Eastern Creek Business Hub Stage 3 – Meeting with TfNSW on Infrastructure

Meeting Minutes

1. FPA provided an overview of the Eastern Creek site, masterplan and proposed Stage 3 Concept Plan. Noting the planning pathway is 'Amending Concept Plan' with DPIE.

INTERSECTION LAYOUT - CONCEPT LINEMARKING PLAN
SCALE: 1:250 @A1

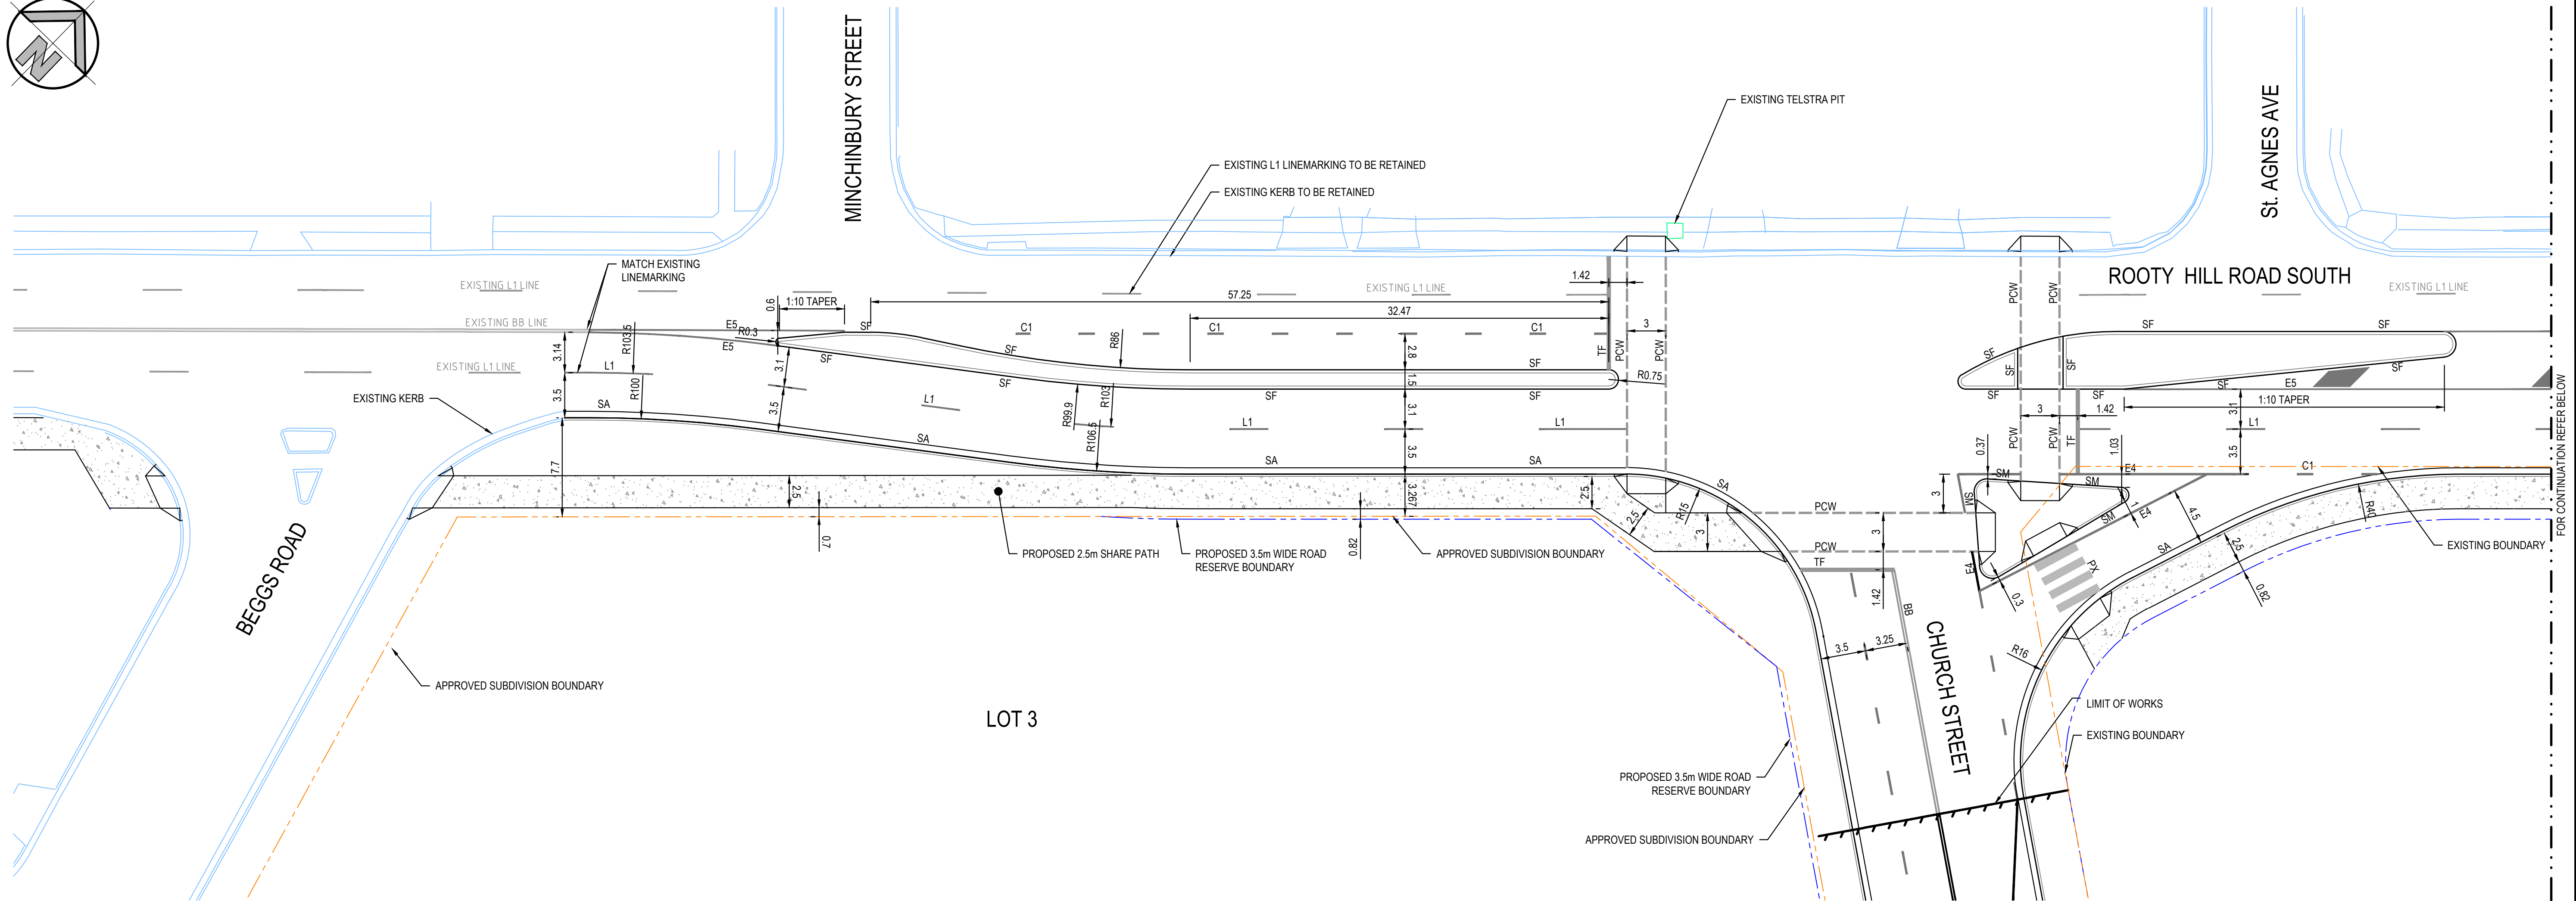
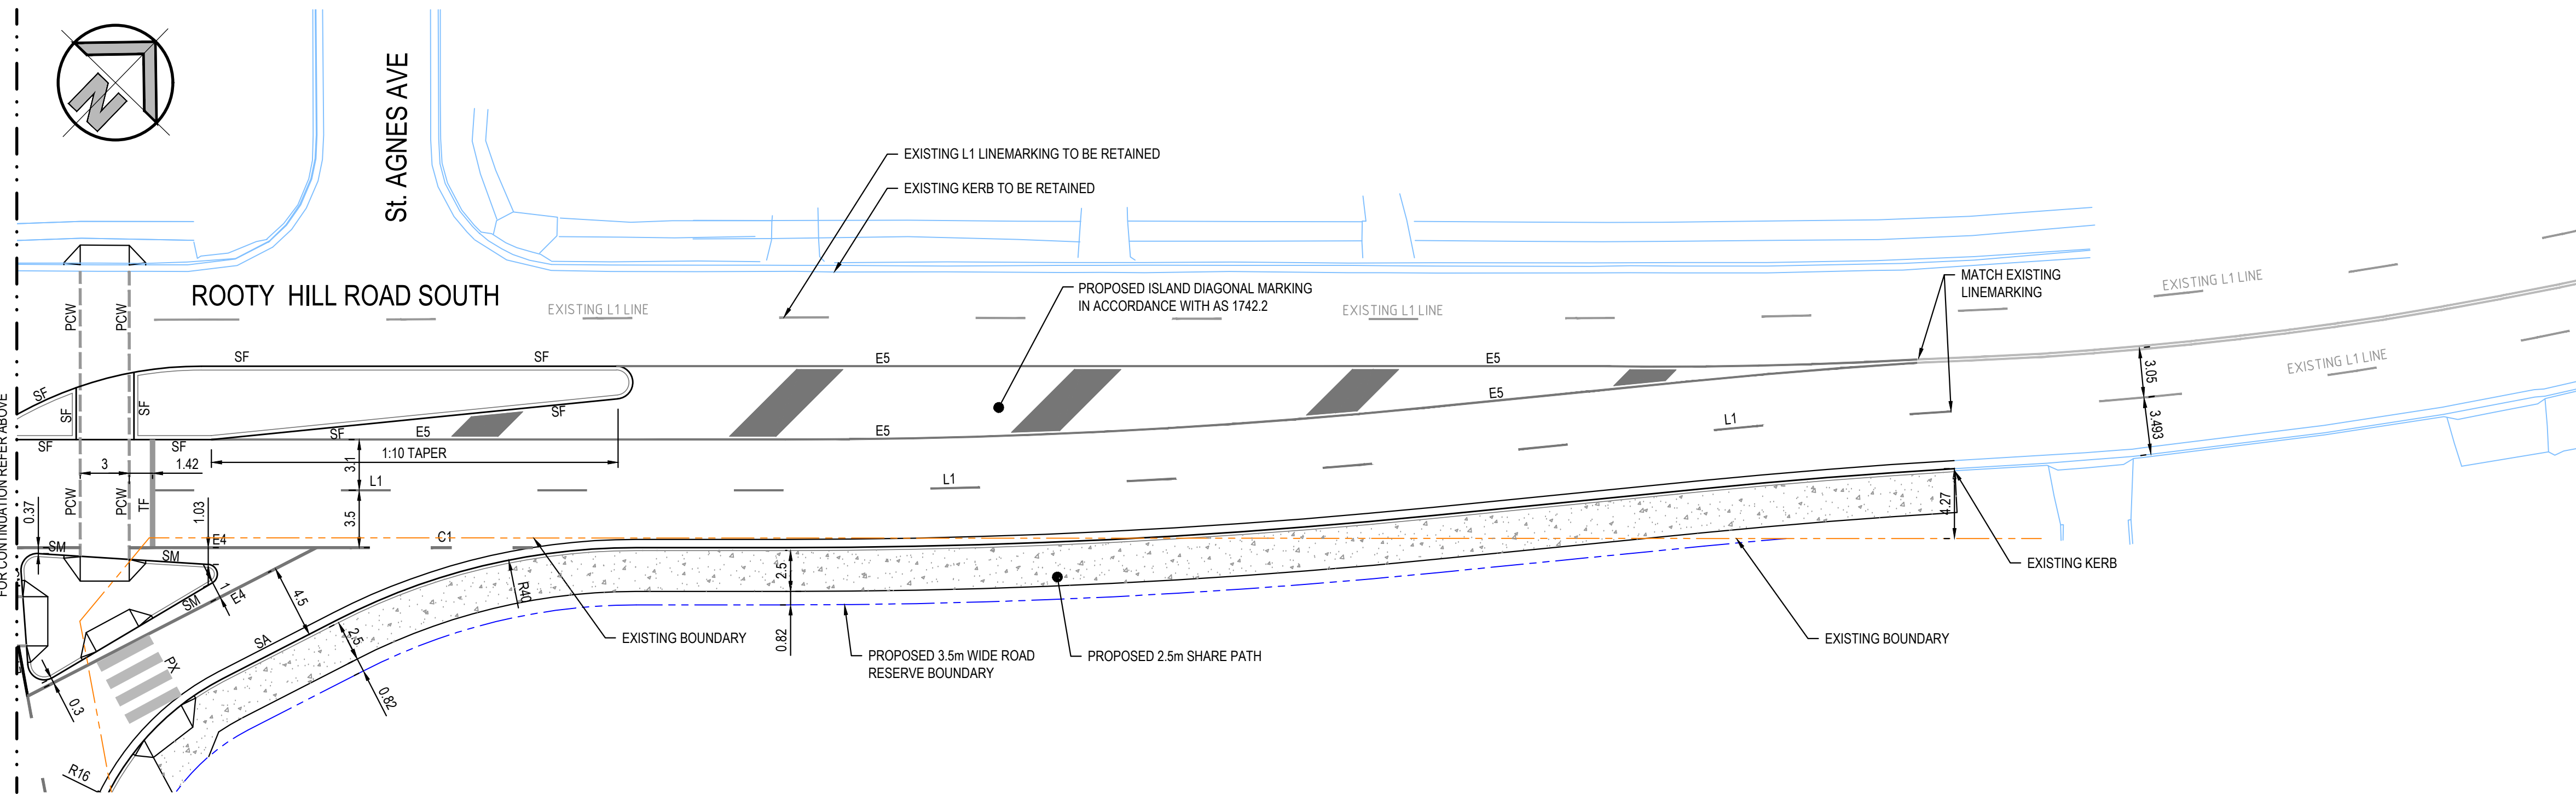
- Does not support right turn movements to/from St Agnes Avenue and Minchinbury Street (TfNSW reasons – too close to signals, safety of turning movements, conflicts with phasing). Concept design to be amended with median extended to prevent right turns.

- Pedestrian crossing on RHRS (north of Church Street) to be a single crossing – easier to provide with no right turn access to St Agnes Avenue.
- TfNSW, FPA and CBRK acknowledge that the current concept plan is to set out the design principals, while detailed design will be included at detailed SSDA stage.

- Left deceleration lane from RHRS to Church St:
 - TfNSW: would like to confirm that the design is not providing left decelerating lane.
 - CBRK / FPA: a left deceleration lane is not being provided, due to the parcel of Council land required for the lane is controlled by both Federal and State environmental policies imposed on vegetation removal.

- CBRK proposes that as a mitigating solution, a high angle left turn slip lane to be investigated to reduce the impact of left turning traffic into ECQ Stage 3 on southbound traffic on RHRS.

- 1) FPA / CBRK to update the Church Street/RHRS intersection design to show:
 - a) Single pedestrian crossing;
 - b) A left turn high angle slip lane;
 - c) Median extended to ban right turns to/from St Agnes Avenue & Minchinbury Street.
